DEXUS ESTATE INDUSTRIAL PARK PROJECT (MP 08_0259 MOD 4) – FUJITSU DATA CENTRE FACILITY – ADDITIONAL INFORMATION – RESPONSE TO COUNCIL COMMENTS

I refer to the Department of Planning and Infrastructure's (the Department's) request for additional information dated 20 December 2012 seeking a response to Holroyd Council's (Council's) comments on the proposed modification to the Fujitsu Data Centre Facility, within the Greystanes Southern Employment Lands.

Revised architectural plans (Site Plan and Ground Floor Plan) for the proposed modification are attached in **Appendix A**. The minor changes to the plans from those submitted with the application are outlined in the following table.

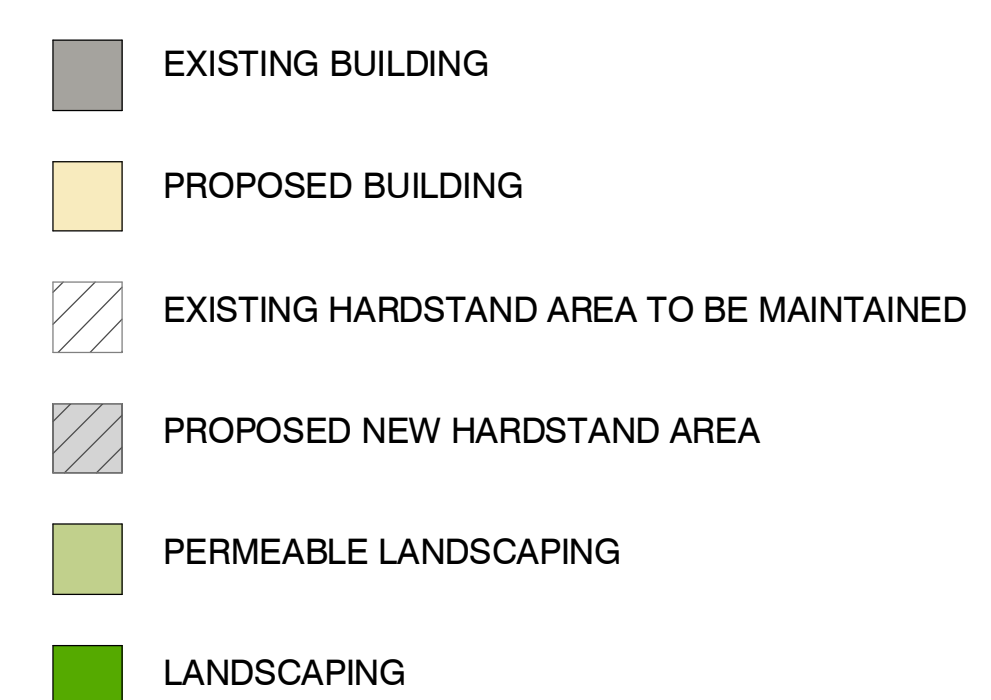
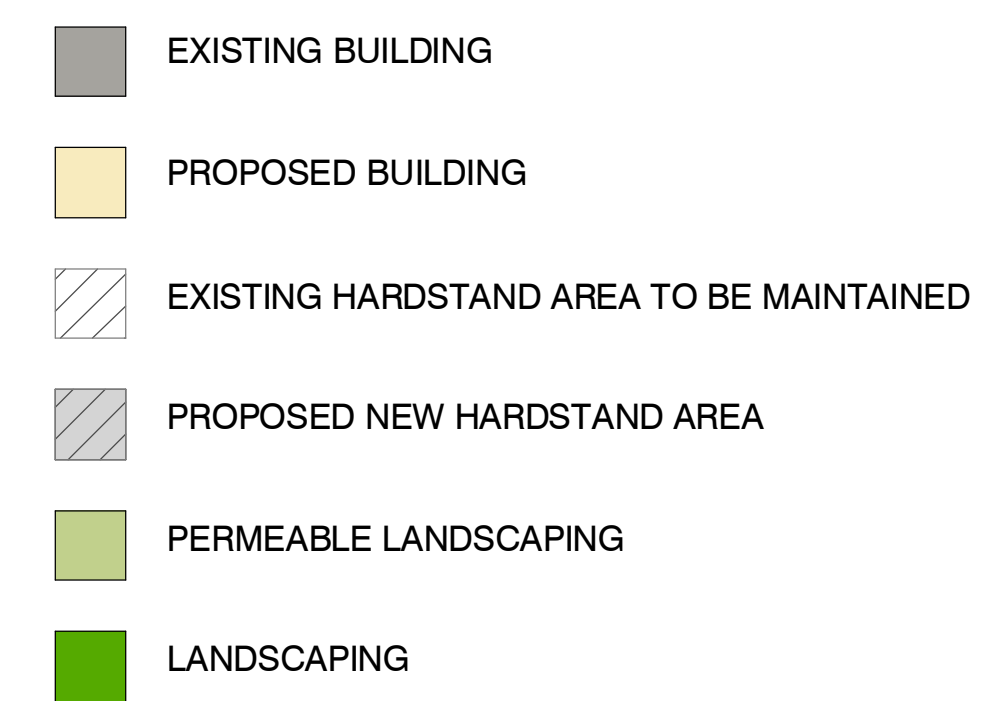
2. Separate pedestrian access	The proposed modification does not involve any changes to the approved access to the site
3. Disabled parking spaces	Disabled parking spaces have been provided for the approved facility, and will be provided for the amended facility, in accordance with AS2890. The Site Plan and Ground Floor Plan for the proposal have been revised to show the disabled parking spaces (see Appendix A).

4. Bicycle parking racks	Bicycle parking racks/bars have been provided as part of the approved facility (5 racks for approx. 10 spaces), and an additional bike rack/bar will be provided for the amended facility (ie. a total of approx. 12 spaces). The Site Plan and Ground Floor Plan for the proposal have been revised to show the additional bike racks (see Appendix A).

Additional swept paths for these vehicles are shown on the revised Site Plan in **Appendix A**. Accommodating these vehicles has required the removal of a small number of car parking spaces opposite the loading dock. The loss of these spaces has been offset through a minor reduction in car-parking space width (ie. to 2,400 mm), which still complies with AS2890. As a result, the revised plans do not alter the total number of car parking spaces on-site (or the total hardstand/pavement areas on site).
